**RE: Manzano High School Gym
Grading and Drainage Plan
Engineer's Stamp Date 6-8-2016 (File: K22D020)**

RE: MANZANO HIGH SCHOOL GYM – K22D020

Minor revisions were made to the Project Data and First Flush notes on sheet CG-100. The following numbered responses (R) correspond to your review comments provided by e-mail on March 31, 2016 (shown italicized).

## PAVING PLAN

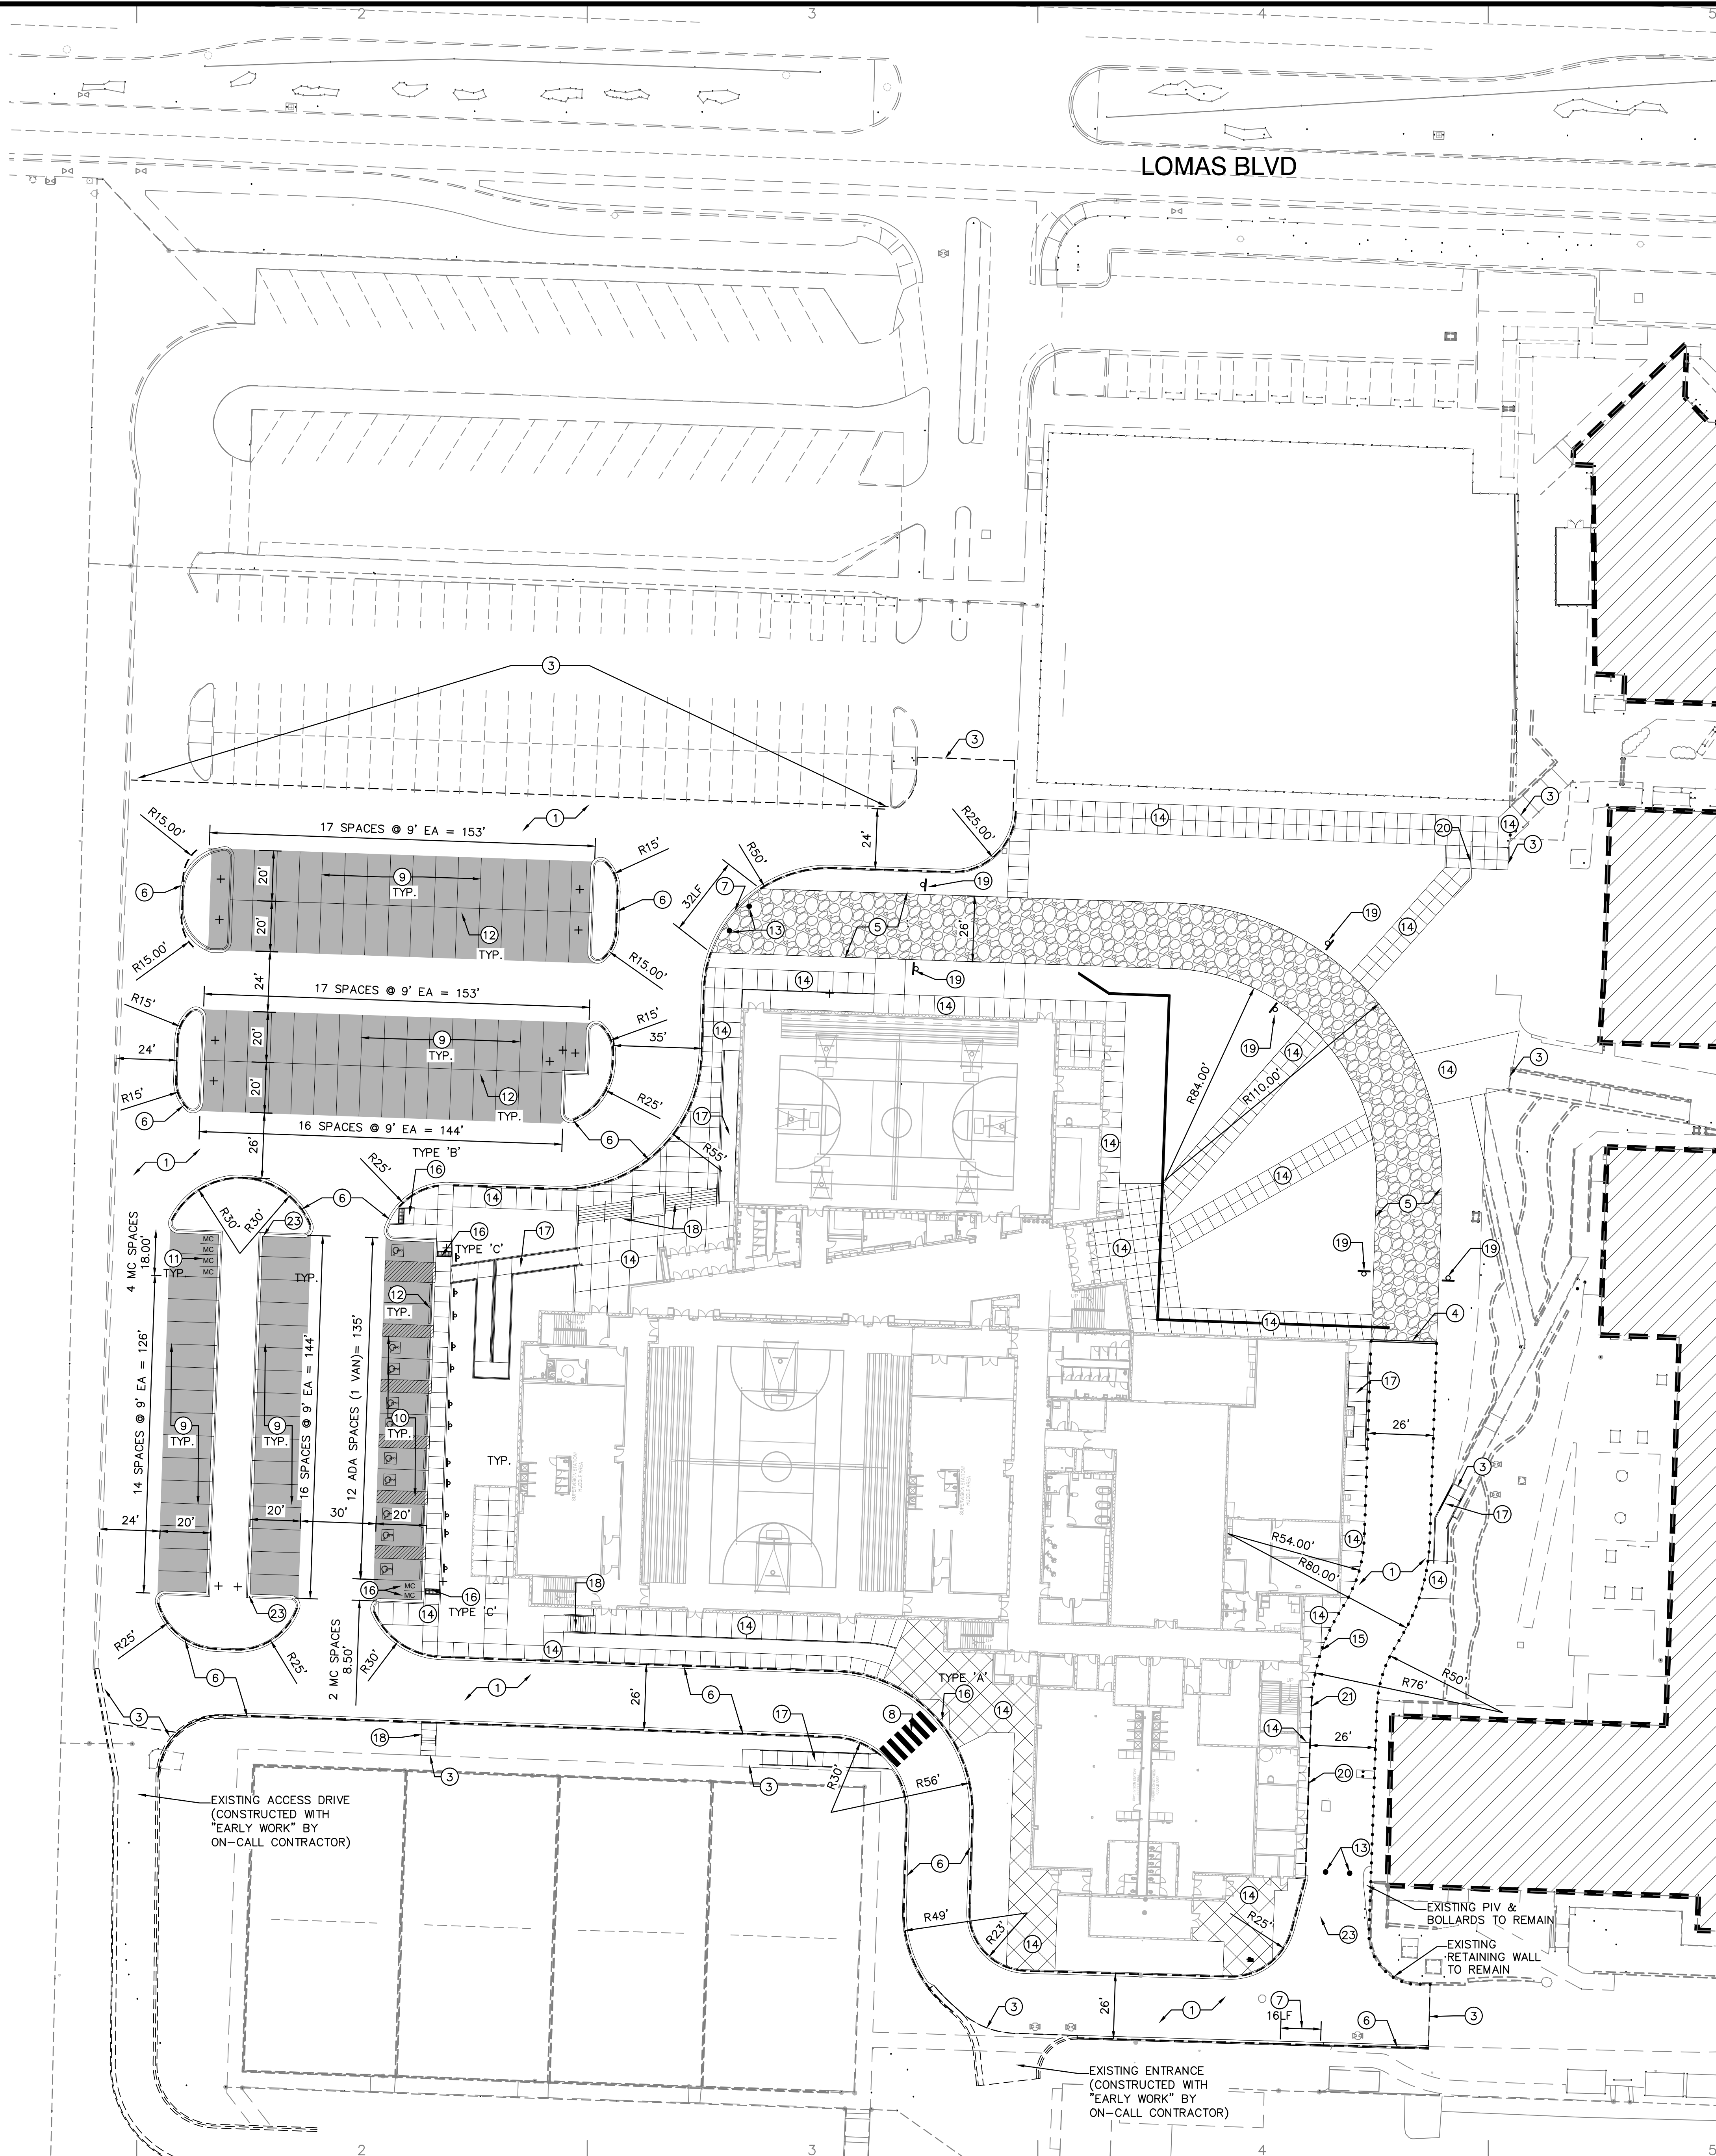
- 3. *Provide the site plan to better understand paving and sidewalk improvement limits.*

3a. *The roadway that wraps around the north side of the building appears to terminate behind the curb without a driveway, and it has a different hatching than the southern access aisle. The keyed note suggests that it is a paved road.*

R: A copy of the paving plan is included for information of the sidewalk improvement limits. Regarding the referenced roadway on the north side of the building, the paving plan calls this out as aggregate base course (as approved by the Fire Marshal for firetruck access). Per the paving plan, the curb at the terminus is to be mountable median curb.
